Date: 6th April 2022
Ref: ML/GML21156/LR001

RE: Local Authority Response – Land off York Gardens, Gosberton

Gleeson Developments Ltd (the 'Client') have asked Geo-Matters to provide a response to Local Authority comments which the clients received on 3rd Feb 2022, please find my response in order as presented:

Site Investigation Plan

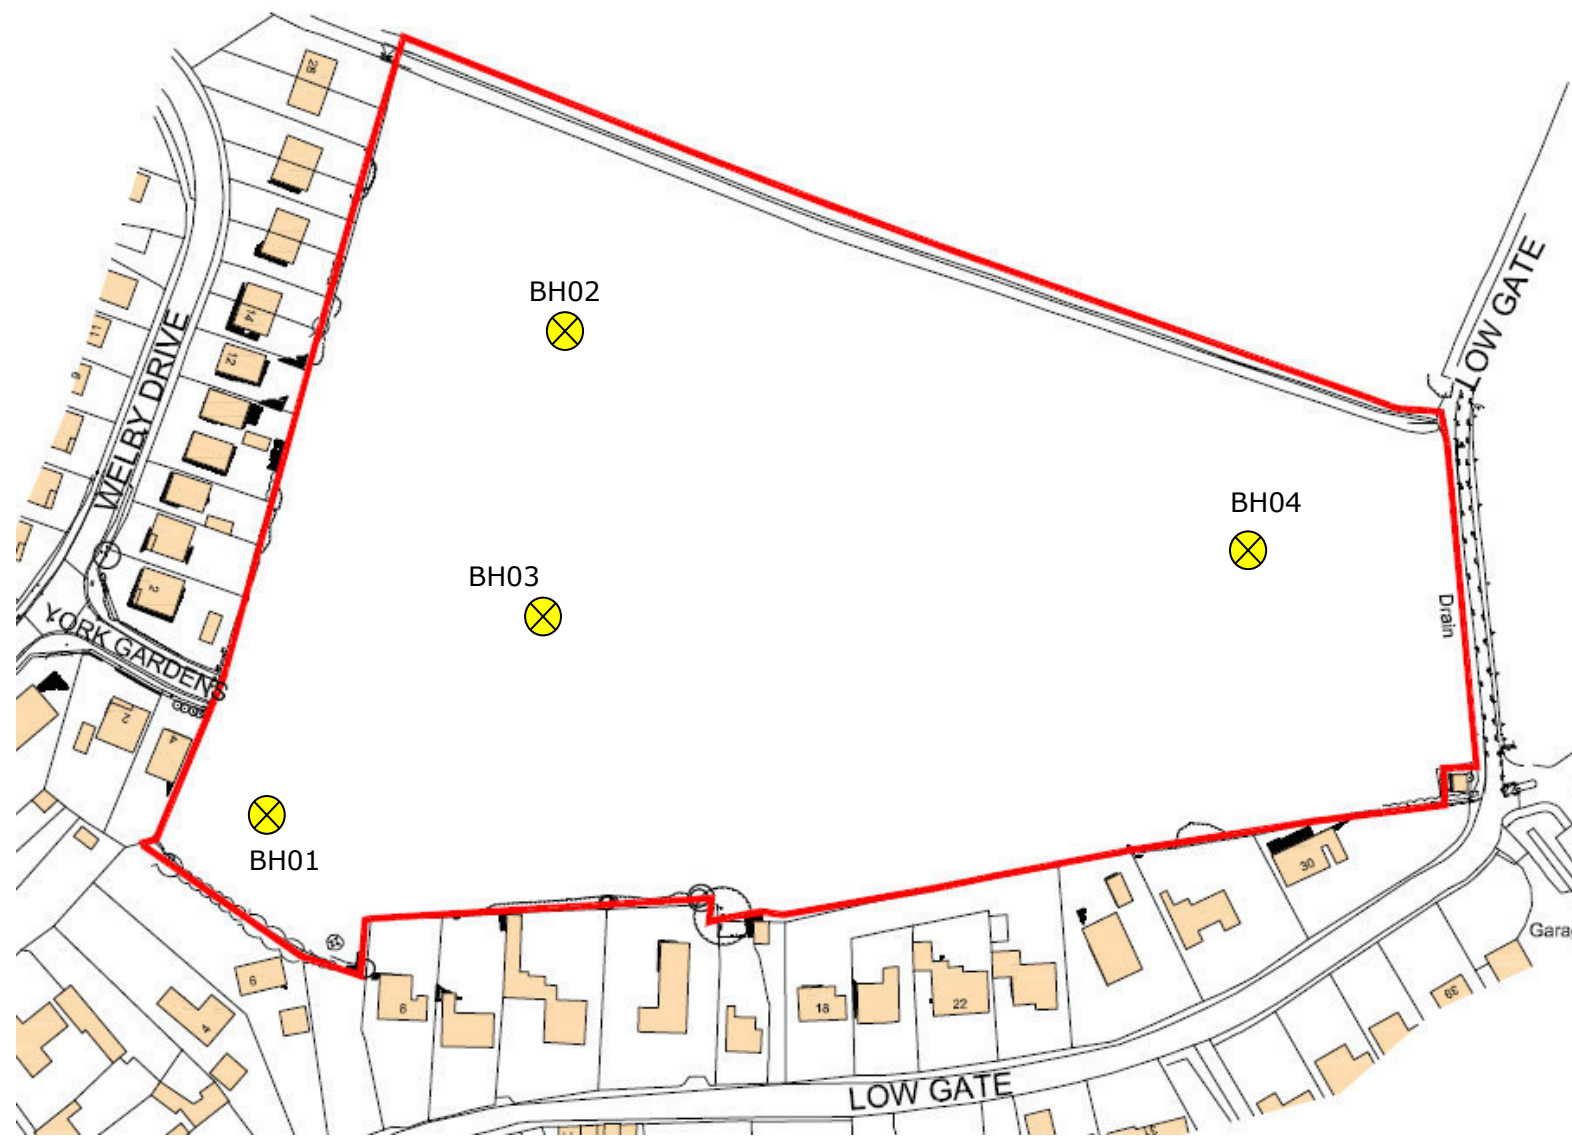
2. There is no map of trial pit locations, so it is not possible to identify if the potential source of backfilled land (former ditch) was targeted. Please can this be provided, and comment made? It would appear that all plans were not included in the original report, this has been rectified and copies are included within this letter report. It can be seen that several exploratory investigation locations are targeted to the former drain that was noted on the historical plans between 1887 and 2000.

4. As there is no full site plan, it is not possible to comment as to whether this represents sufficient characterisation of the site. Responded in Point 2.
